Application Ref:	3/2020/1058	 <p>Ribble Valley Borough Council www.ribblevalley.gov.uk</p>	
Date Inspected:	6/1/2021		
Officer:	BT		
DELEGATED ITEM FILE REPORT:		Decision	Approval

Development Description:	Proposed summer house extension to outbuilding.
Site Address/Location:	Abbott Barn, Black House Lane, Chipping. PR3 2NR.

**PROPOSED ELEVATIONS**

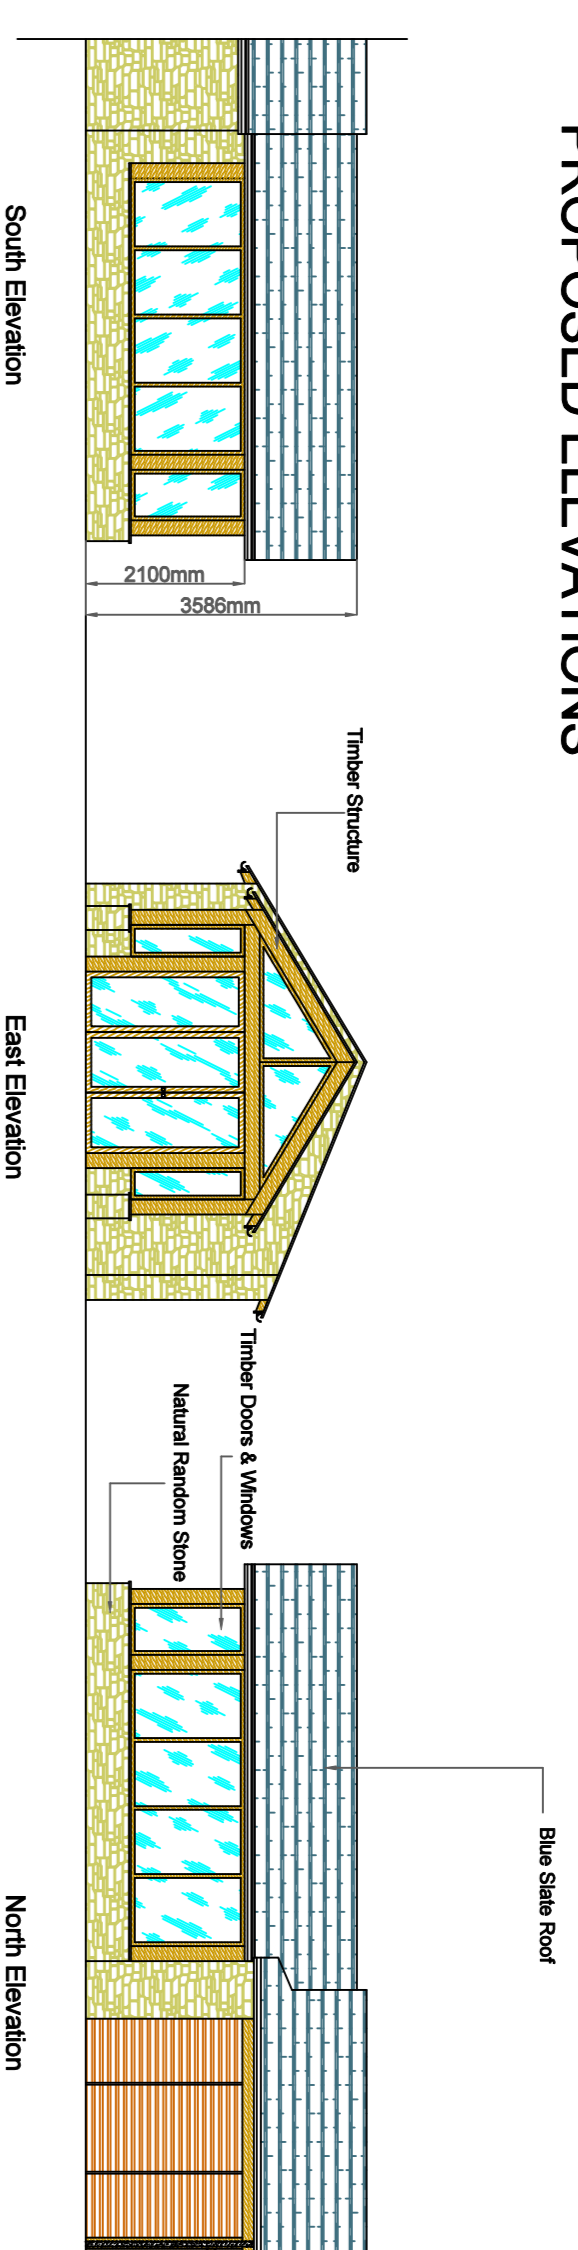
The proposed extension will contain numerous windows on its North, South and East elevations with the windows on the Northern elevation facing towards windows on the Southern elevation of Abbott Farm. However, these windows are located at a distance of approximately 38 metres away therefore the proposal will not compromise the privacy of the neighbouring residents, nor will it have any detrimental impact upon their provision of natural light or outlook.

The proposed extension will be subordinate to the existing garage in terms of size in as much that it will be smaller in both width and length and will not exceed the height of the garage's eaves and roof pitch.

The extension will have an outward projection of 5 metres with a significant amount of glass on all of its elevations and will be partially visible to motorists and pedestrians travelling Northwards along Black House Lane and largely visible from the Public Right of Way that crosses the Eastern edge of the property's curtilage. As such, the proposal will have some impact upon the aesthetic of the surrounding AONB.

**LOCATION PLAN**

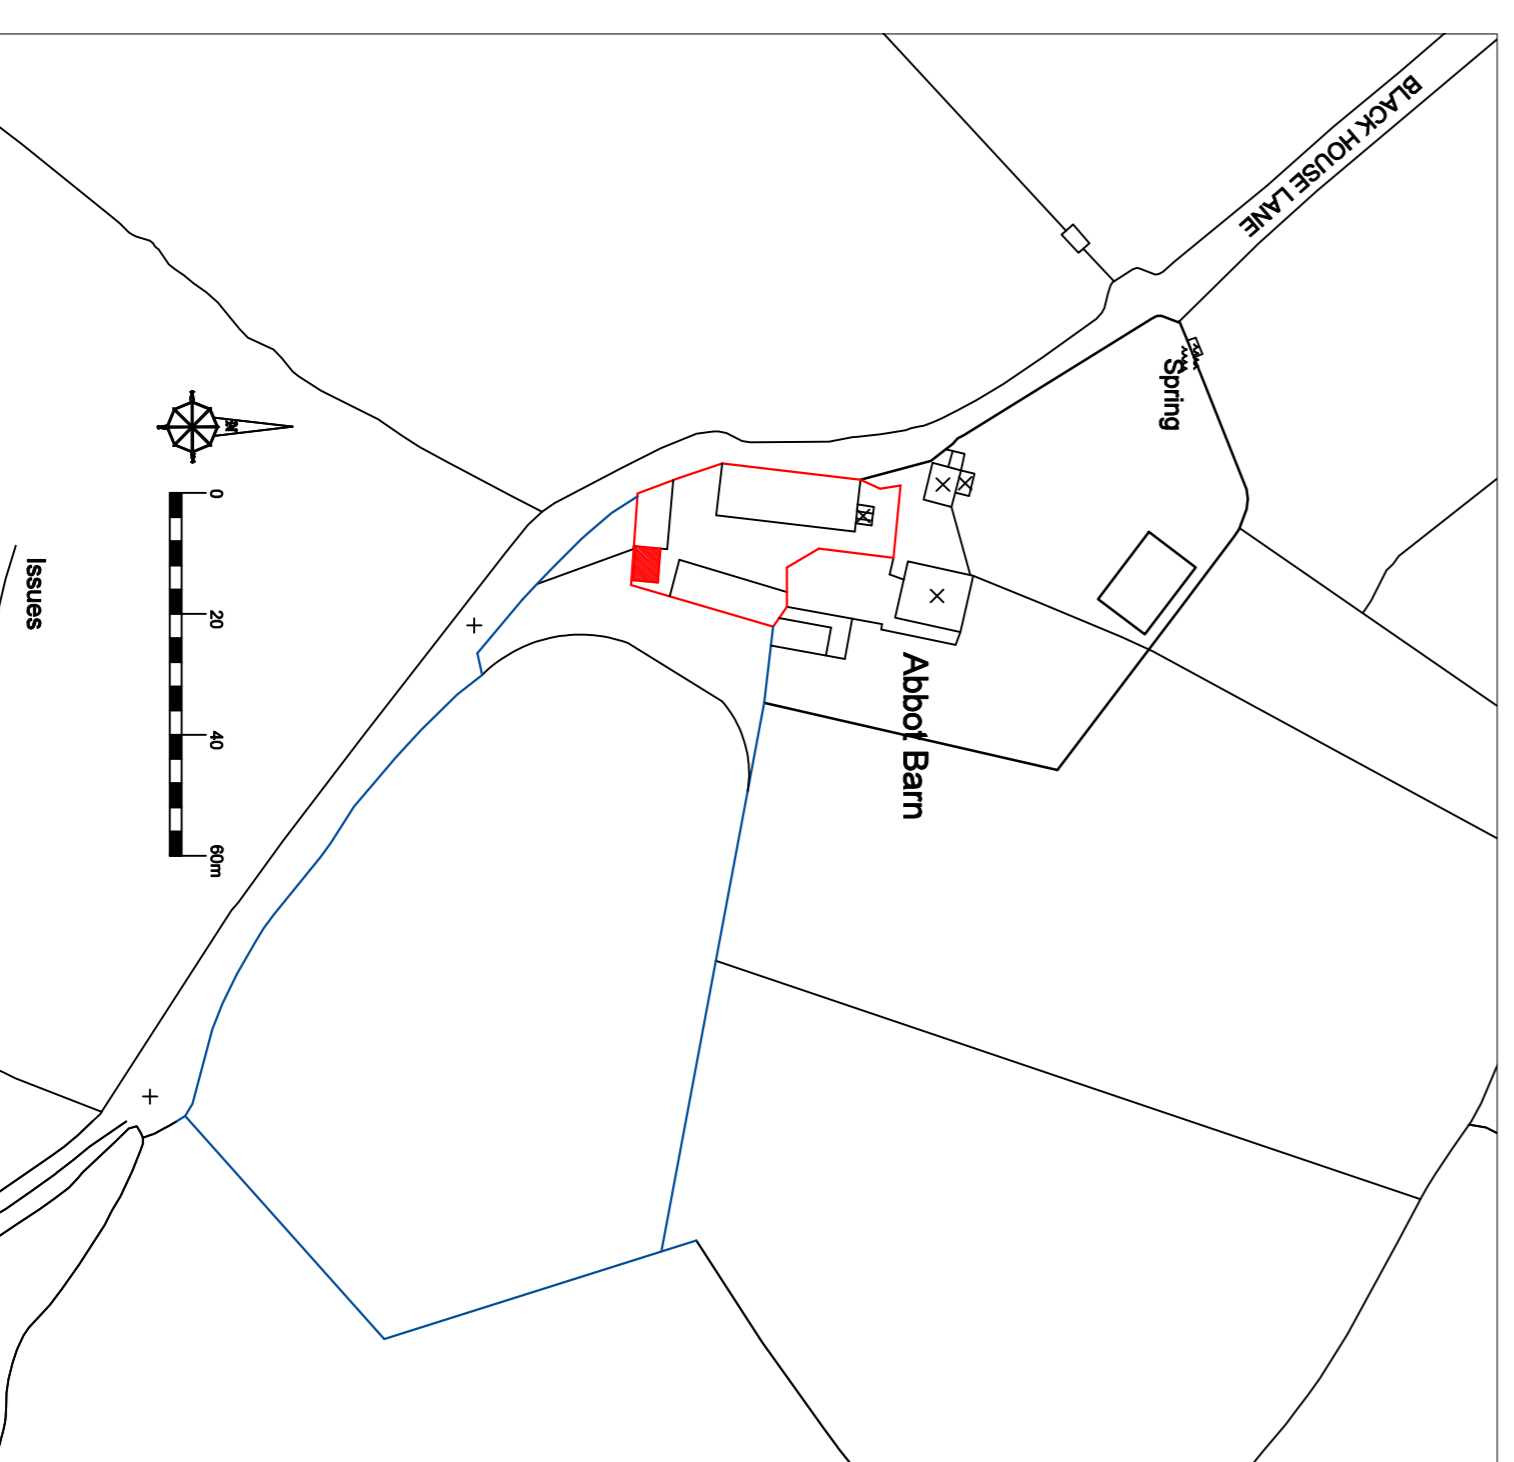
The most recent development in relation to the proposal dates back to 2011 when an application to convert the existing barn on site into a dwelling was granted planning permission. The original Location plan submitted for the current application was noticeably different to the plans from the 2011 application in as much that it denoted a considerably larger area of residential curtilage on the Eastern section of the proposal site than was depicted in the 2011 application.

The applicant has since submitted an amended Location plan which is more representative of the plans from the 2011 application and has confirmed that the proposed development does not involve any extension of the property's existing residential curtilage.
